# GRANDVIEW RESERVE

EL PASO PDC FILE NO.  
CDR-228

CONSTRUCTION DOCUMENTS  
TITLE SHEET

SHEET
GR1 05

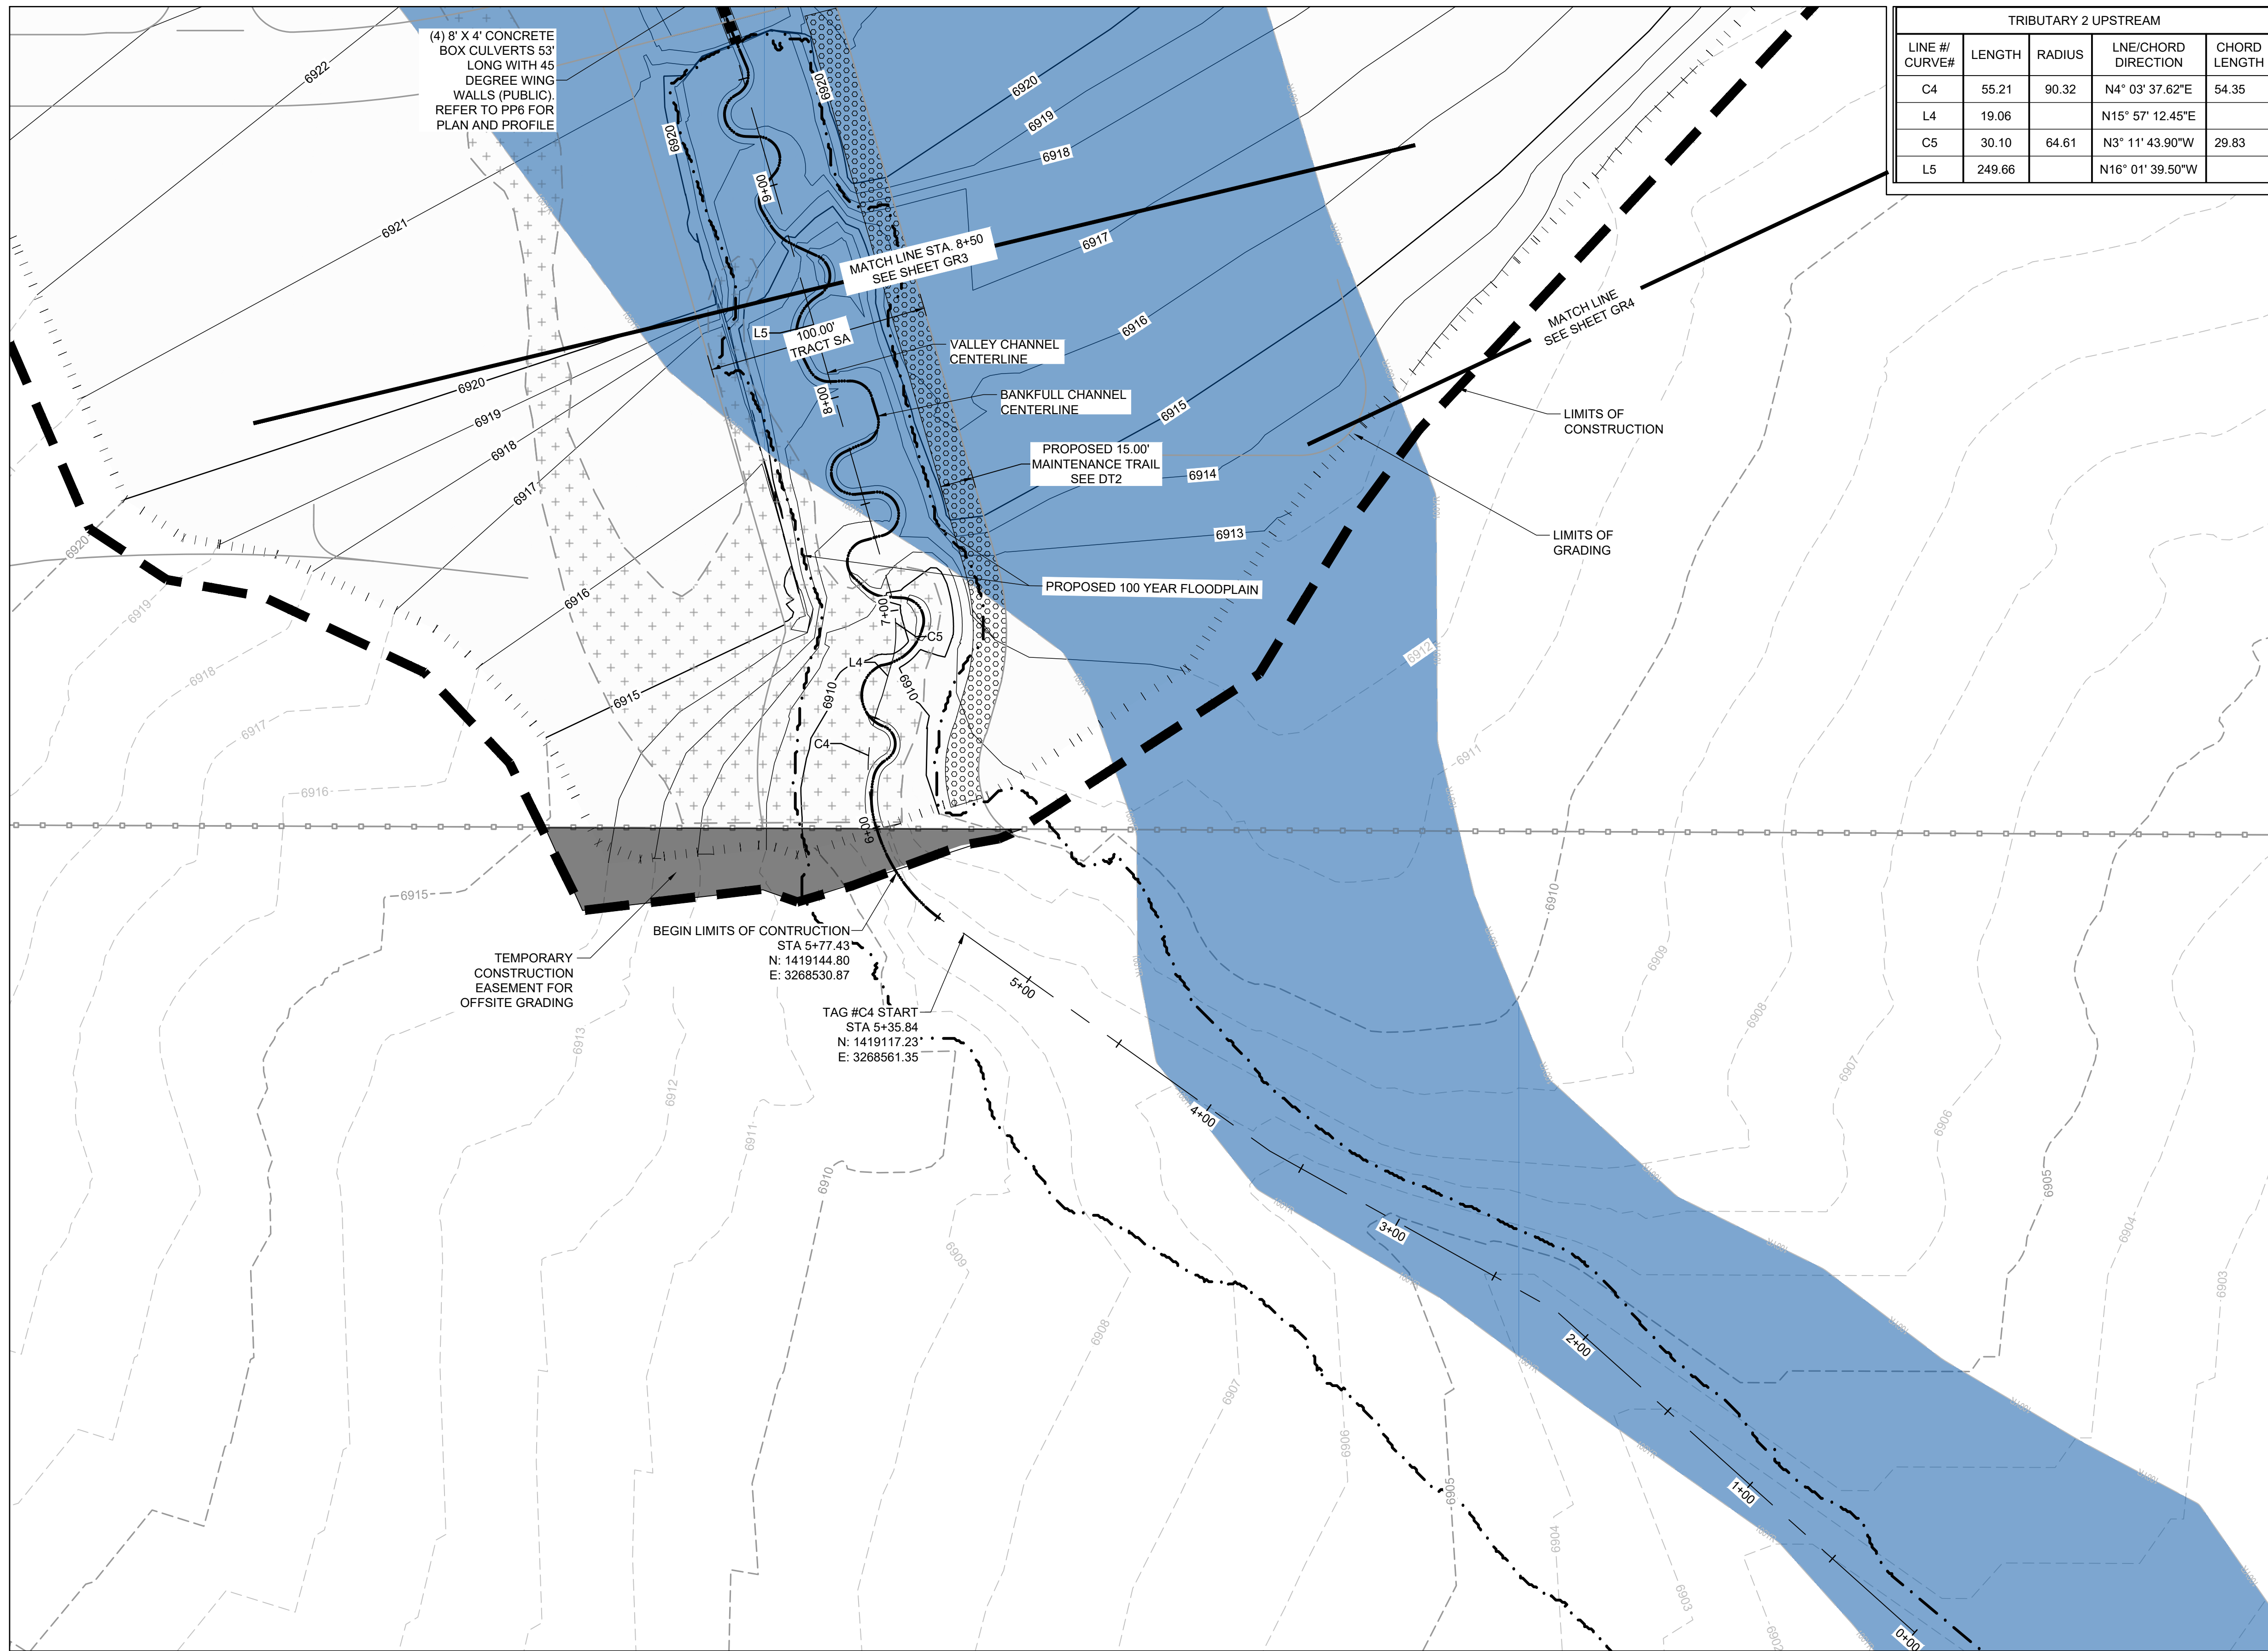
Include name of channel section
